Re: Objections to Proposal to Redevelop Stabling DA 871/2010

We have strong objections to the proposed stable precinct development at Randwick Racecourse. Our chief concerns are;

Picture 11 – Montage View from Wansey Road without proposed landscaping

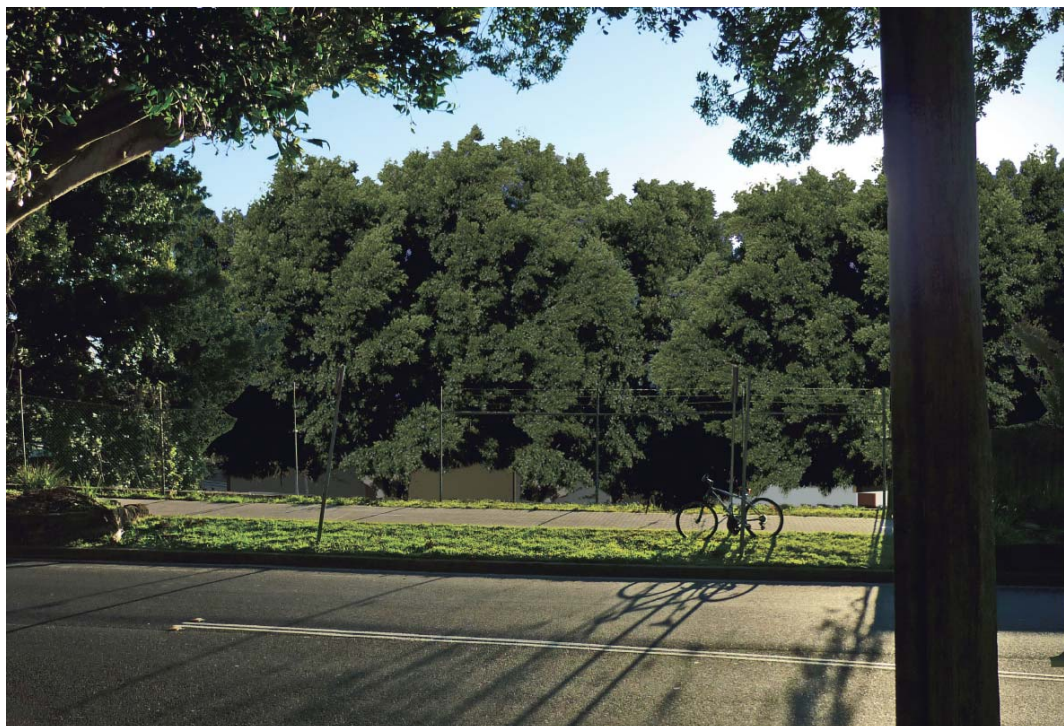
The aspect perspectives submitted are misleading as they show the visual impact from the first floor of no 3 Wansey Rd which is by far the highest set house in the street (the perspectives were taken at a point that is over 10metres above street level). The perspectives need to be re-done showing the visual impact from street height along the main stretch of Wansey Rd and the gardens of other homes.
